WETHERILL PARK

RESOURCE RECOVERY AND RECYCLING FACILITY Response to Submissions

SSD 7401

Prepared for Bettergrow Pty Ltd

PROPOSED FLOOR PLAN
ORGANICS RECEIVAL AND PROCESS BUILDING

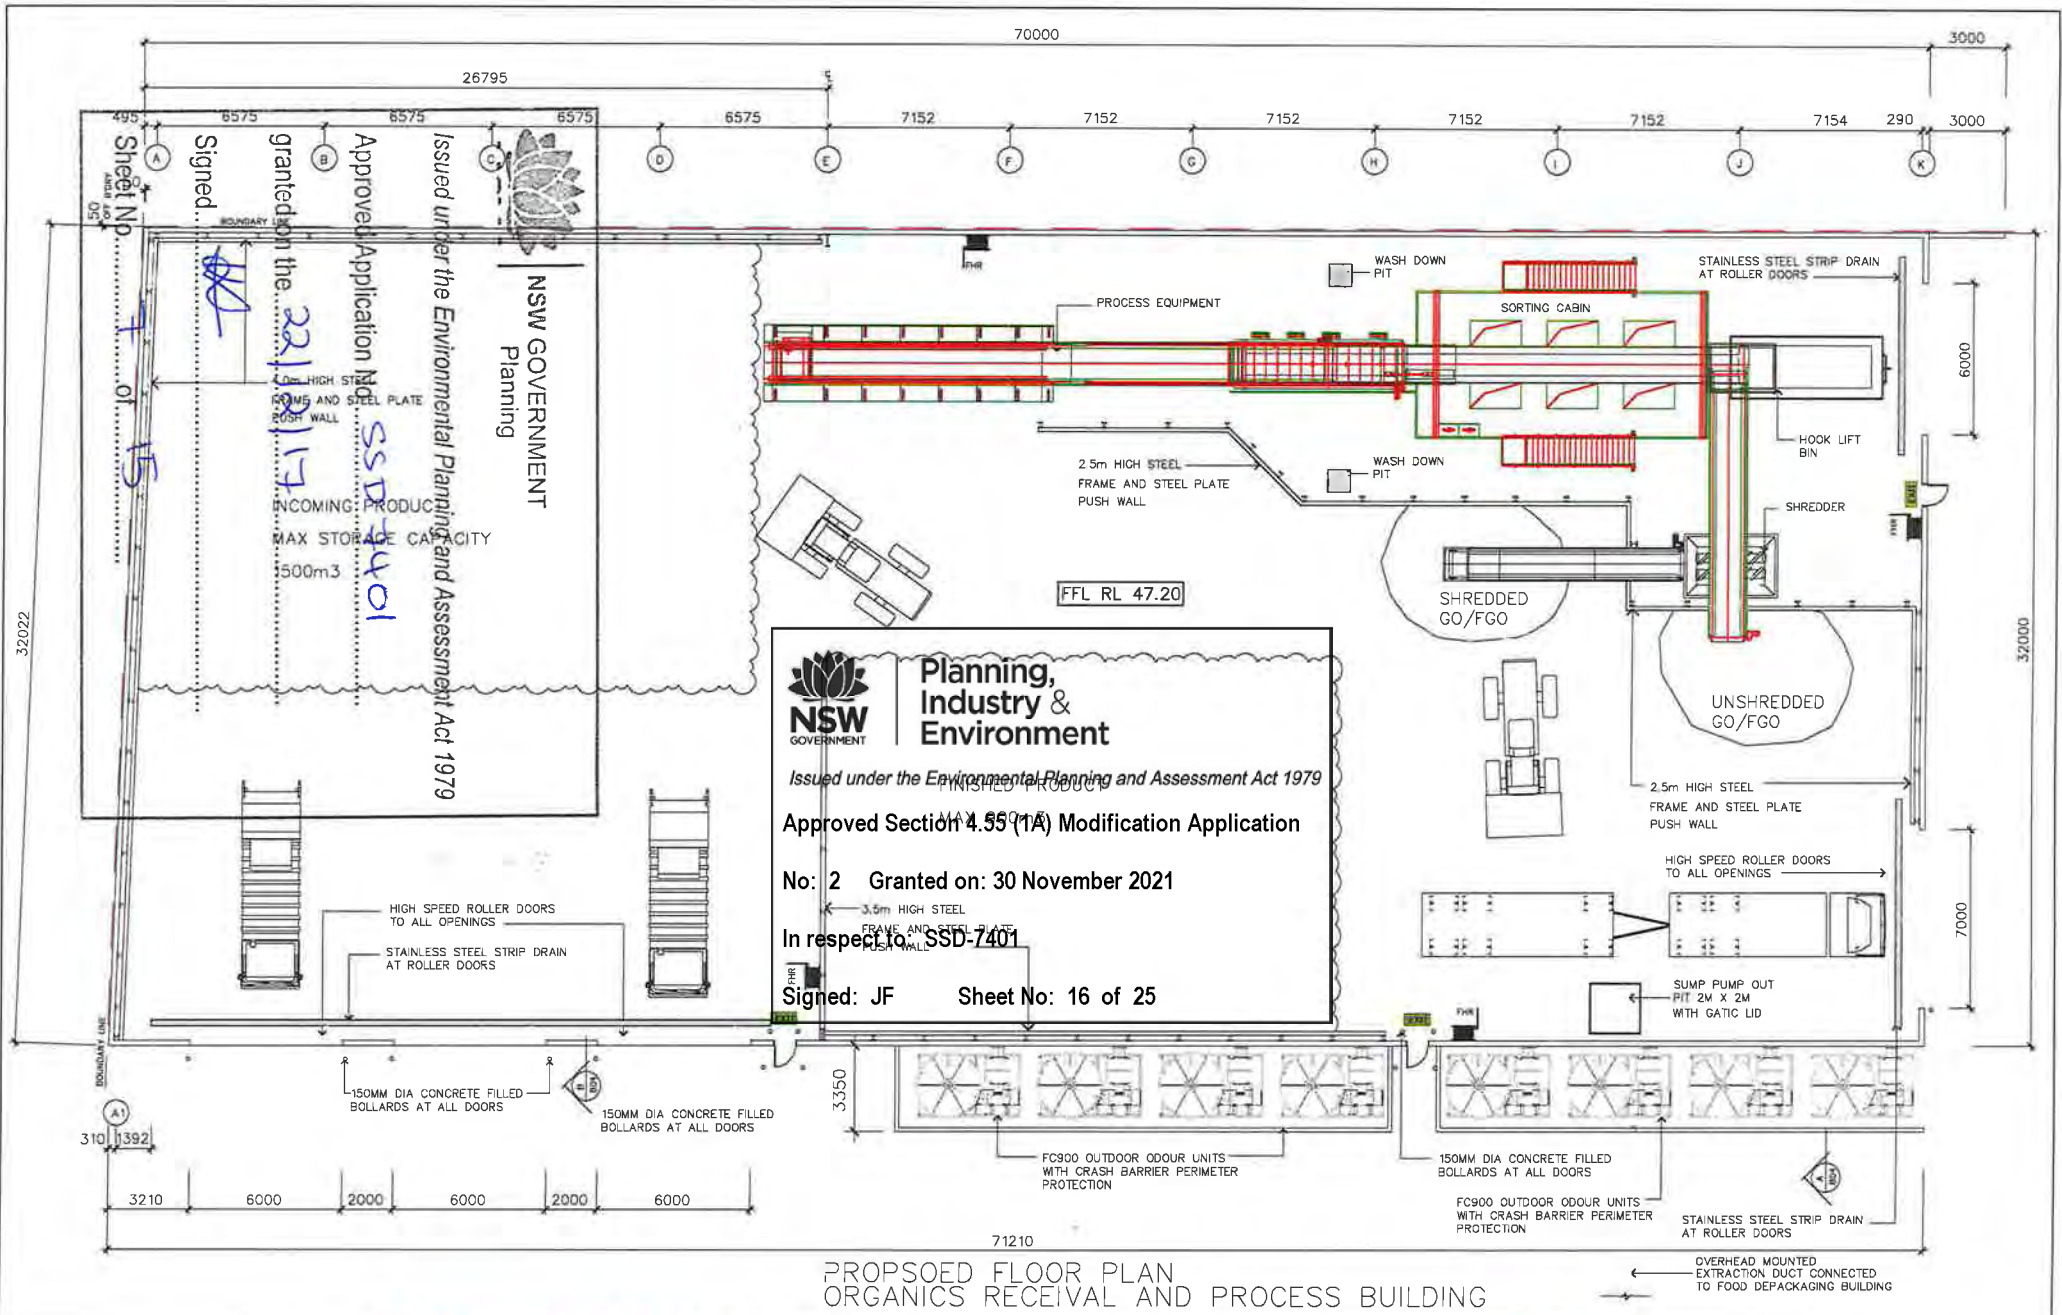
3. Please detail how many tonnes can be stored in the food de-packaging tip pit

The tip pit in the food de-packaging building will be 12.2 metres long, 6.5 metres wide, and 2.2 metres deep (2.55m deep externally). This equates to a volume of 174.46m³ or 174,460 litres of storage. This would allow for the storage of approximately 130 tonnes of material.

Whilst architectural drawings supplied with the EIS show a tip pit depth up to 3 metres, the depth of the pit has been reduced to 2.2 metres internally (2.55m externally) to ensure that the base of the pit does not exceed RL44.5m which is the minimum base depth to ensure the groundwater table is not intercepted. This specification is as per the recommendations of the Groundwater Impact Assessment prepared for the EIS. Refer to **Appendix 2**, **Sheet C01** of this report for a revised plan of the Food De-packaging building and the revised tip pit depth.
